EPC file no COM2030

## ***Legacy Church – Green Mountain Falls: Drainage Revision Memo***

Thank you for discussing the minor changes associated with the Legacy Church – Green Mountain Falls project. The intent of this memo is to discuss the minor revisions made to the site plan and erosion control plan (which will be uploaded in concurrence with this letter), as well as to confirm the adequacy of the current storm sewer and detention pond systems with these revisions.

REV: 7/15/20  
 REV: 11/22/19  
 REV: 10/18/19  
**SITE PLAN**  
**SHEET 3 OF 14**

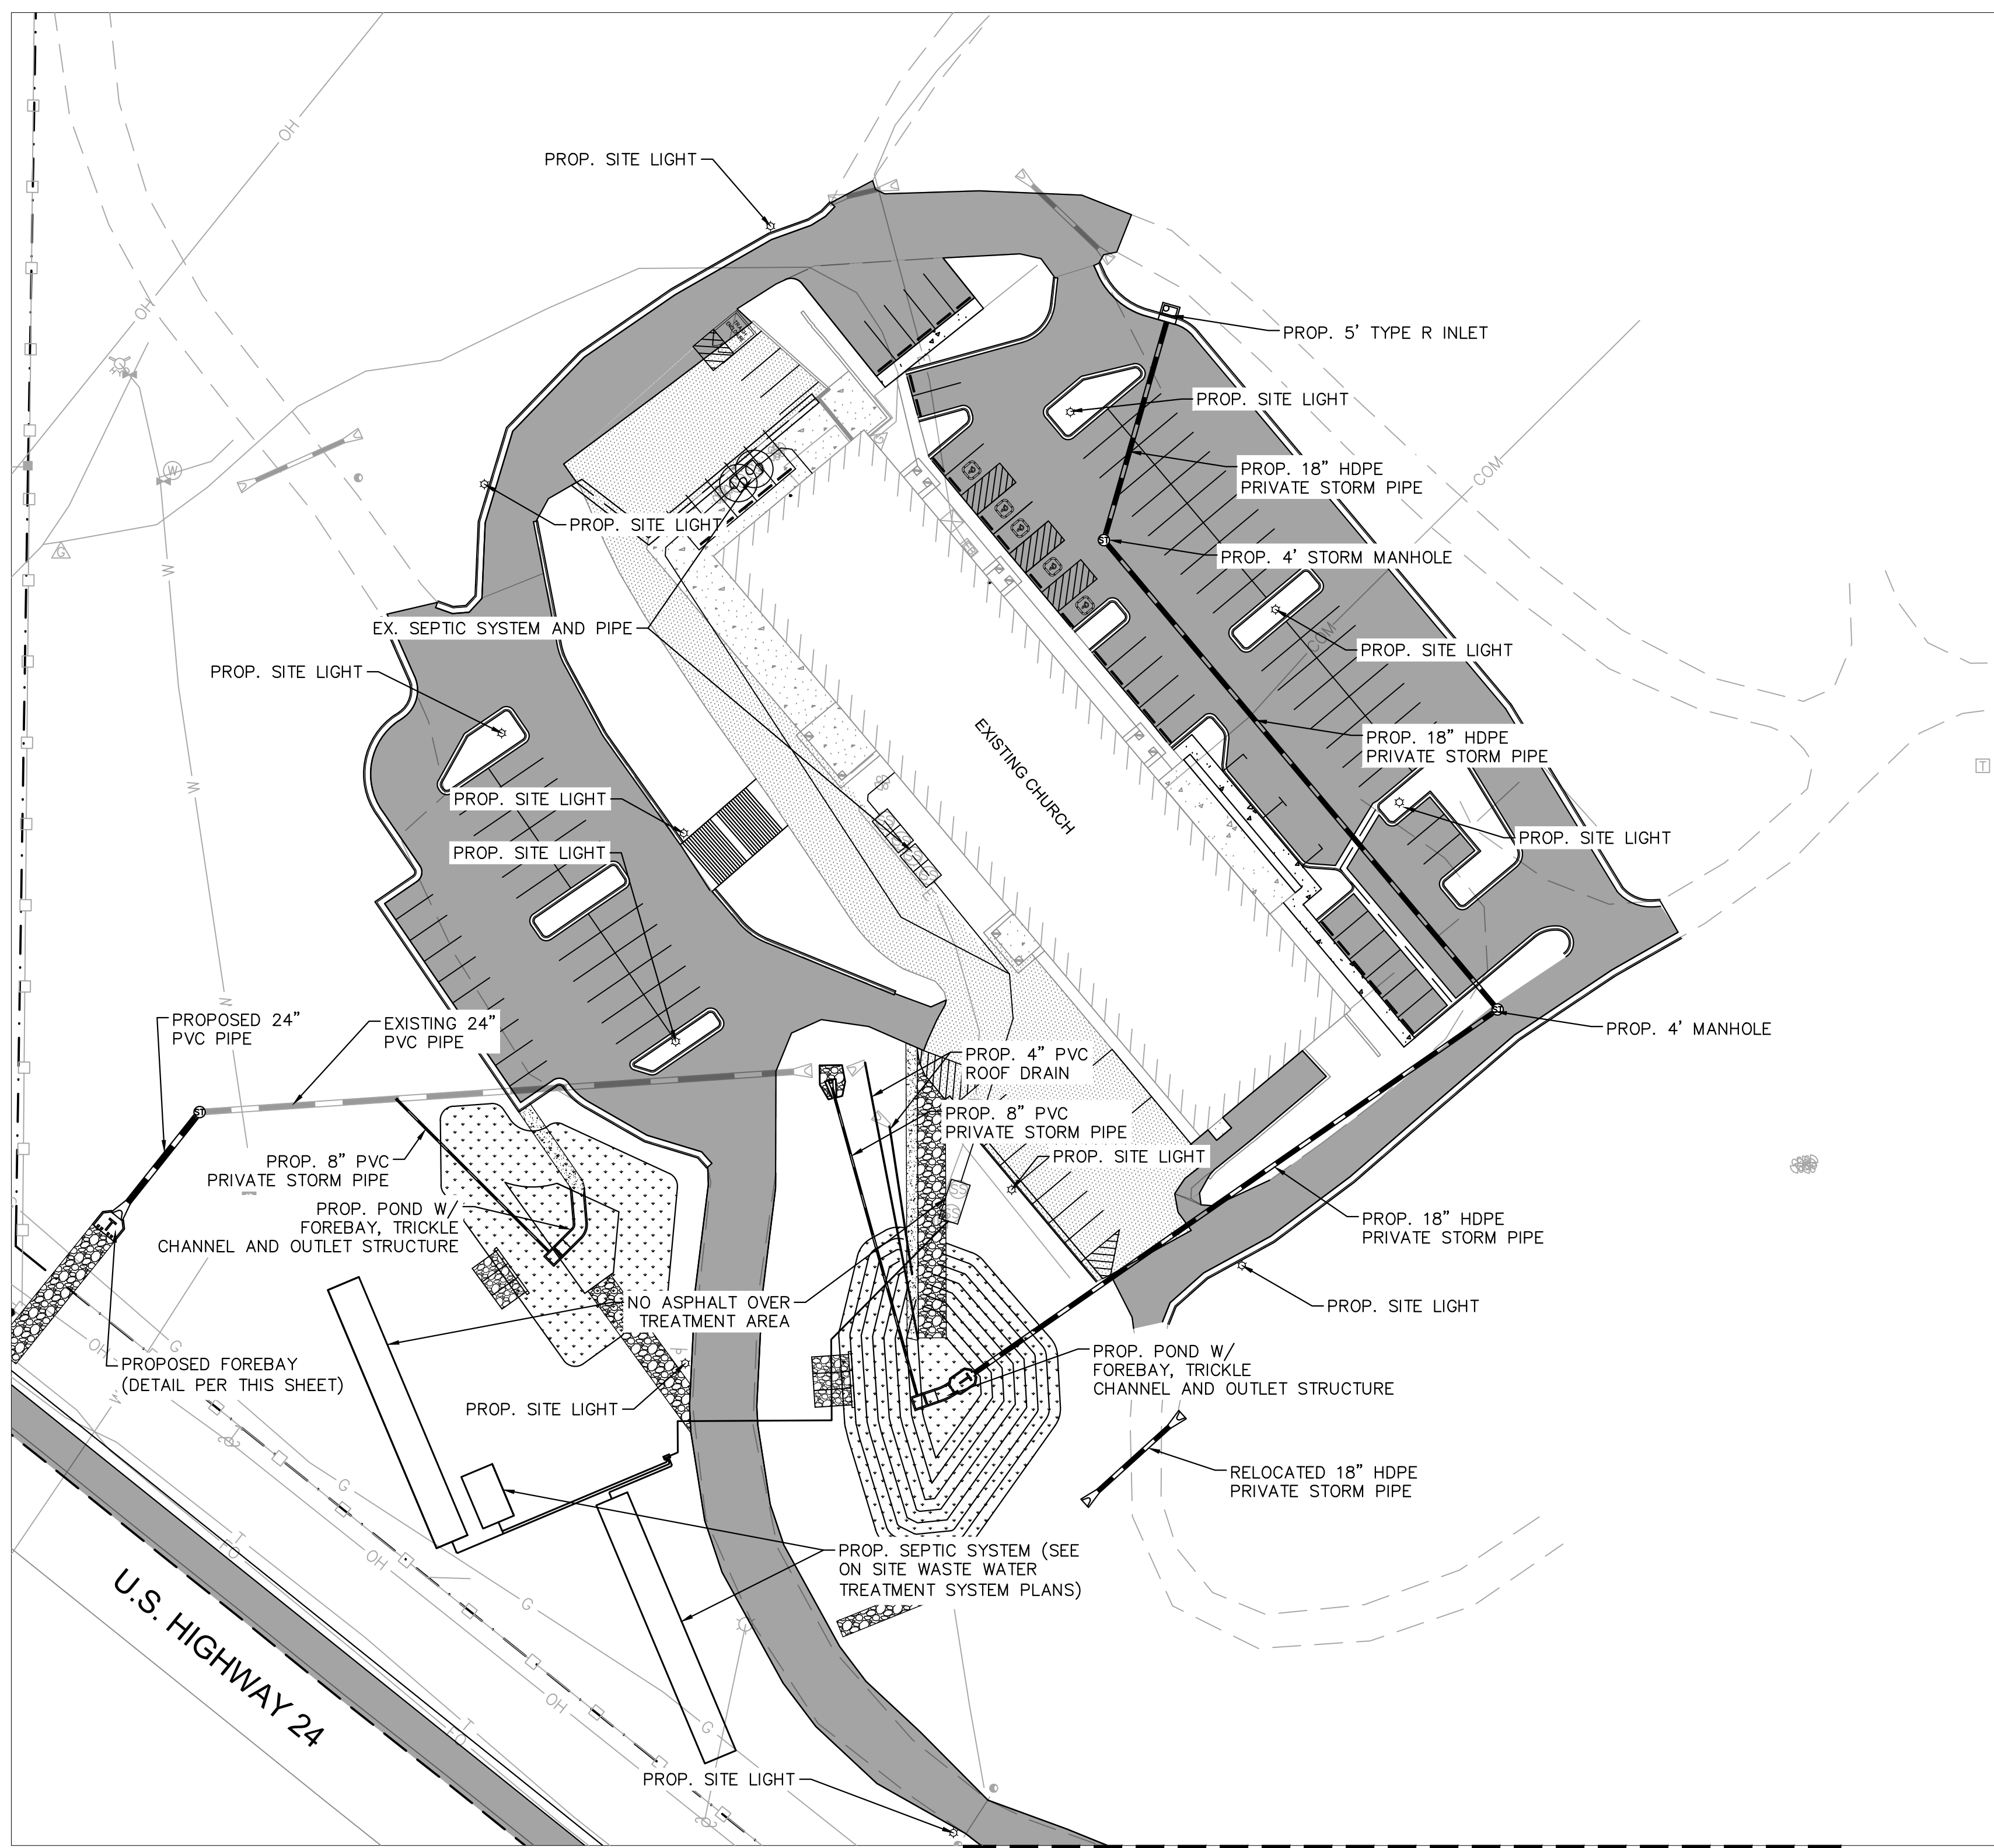
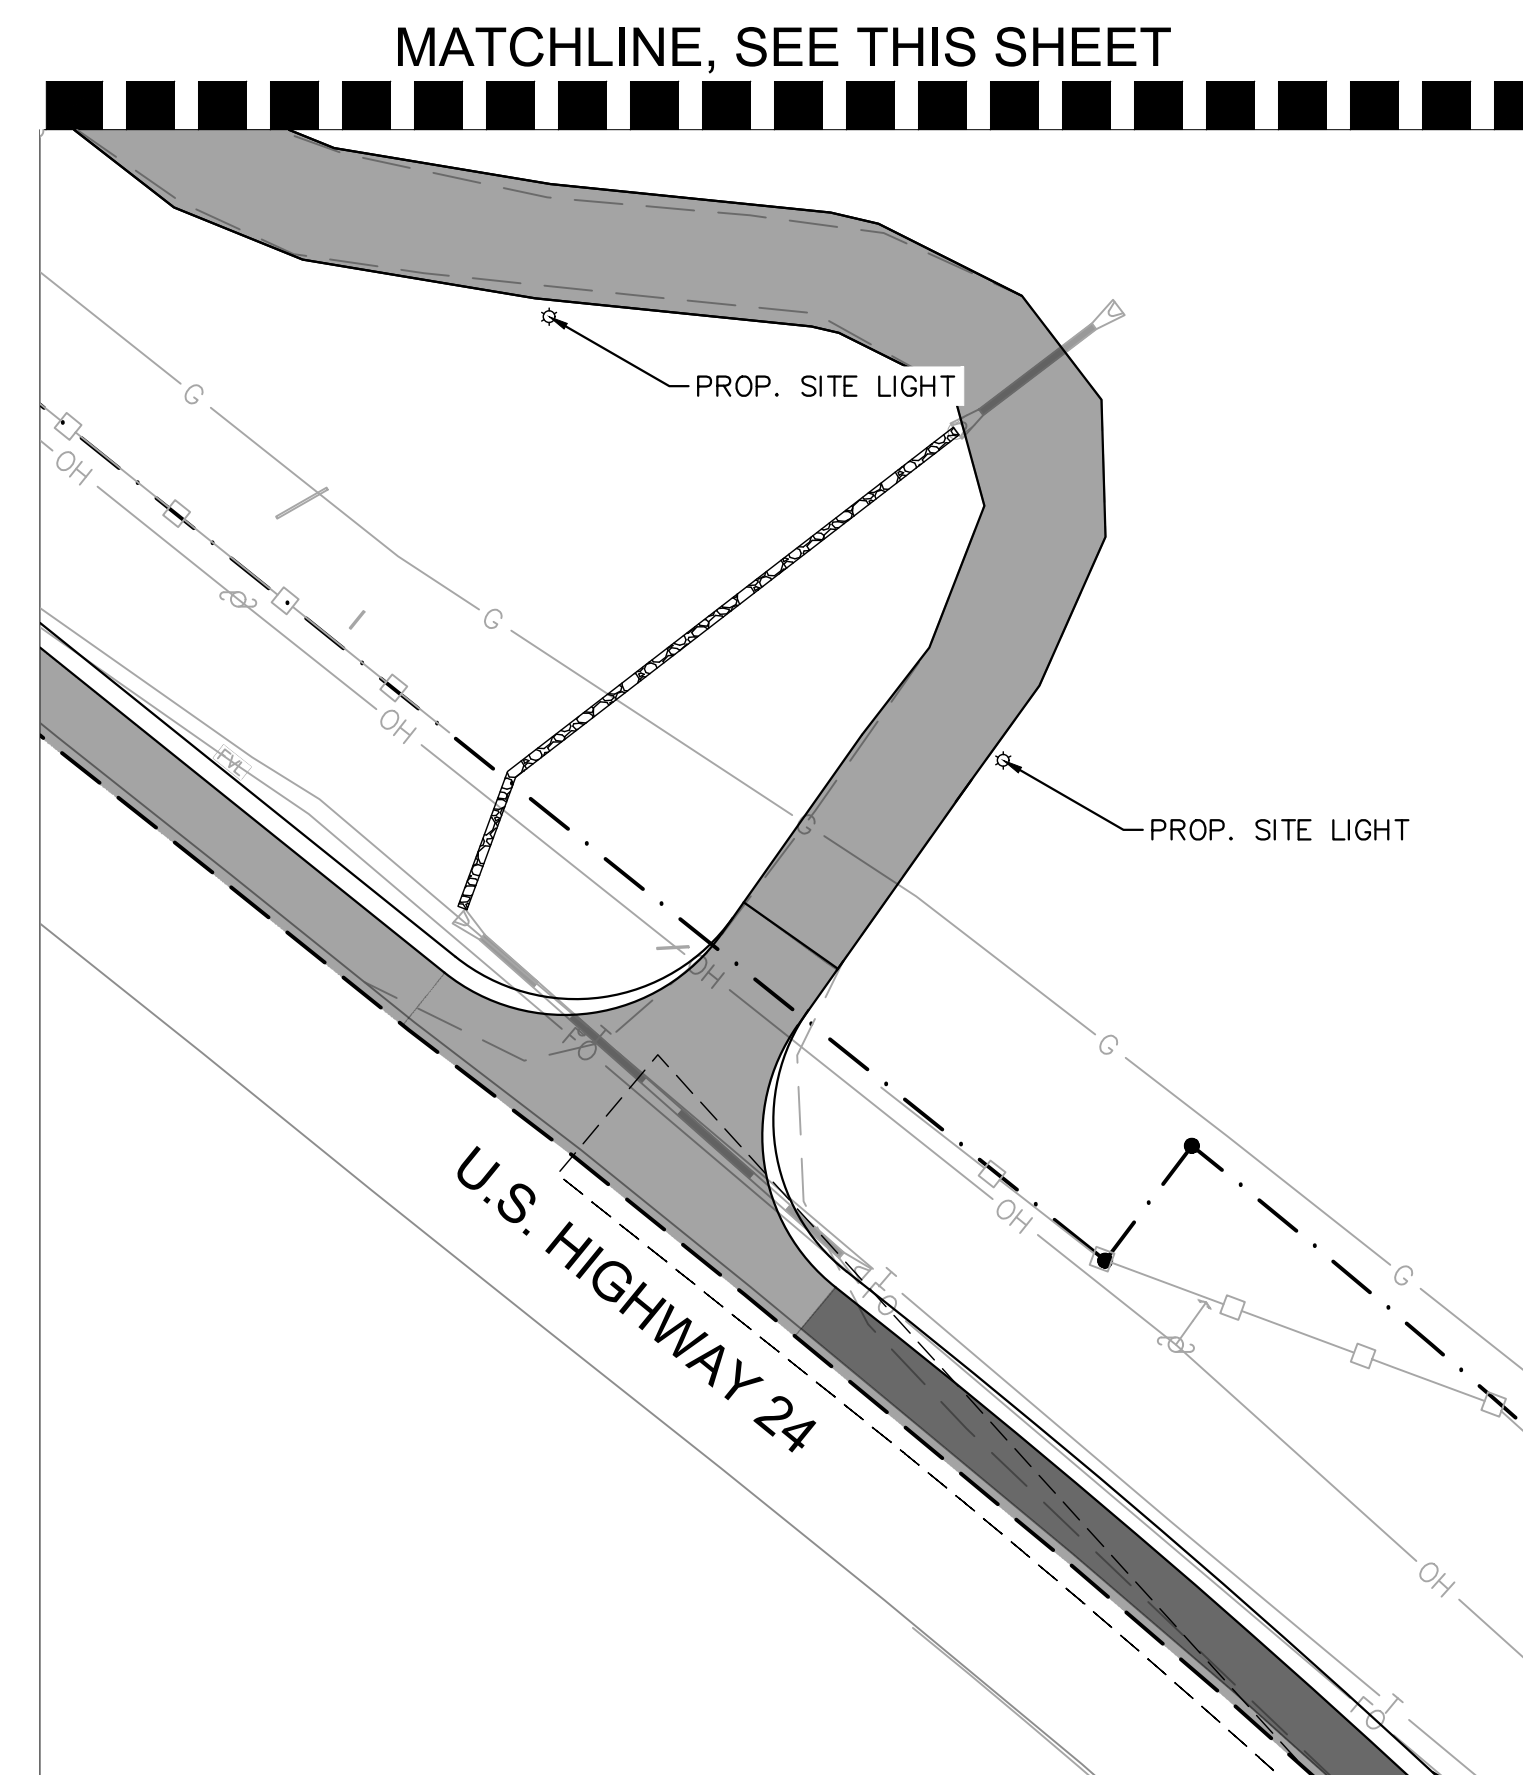
2. With the addition of the RTU pad along the northeast side of the building, the sidewalk shifted as well as some parking spaces and islands. After this shift, the proposed site plan includes 117 spots (with 106 as the required minimum). This is sufficient from a code perspective.

3. All ADA stalls have been relocated to a common location along the north side of the building, which will not adversely affect parking counts or detention pond design.

4. Curb and gutter has been added along the drive aisle at the bottom of the proposed staircase on the south side of the Site. This does not adversely affect the drainage patterns for this basin.

5. The proposed trash enclosure on the west of the building has been shifted slightly for constructability purposes. With this shift, a 4' concrete crossspan was added to ensure flows do not enter the building and follow existing drainage patterns. An additional 4' concrete crossspan was also added in the northeast drive aisle for the same reasons. All flows are directed to the approved design points and do not add any additional impervious flows.
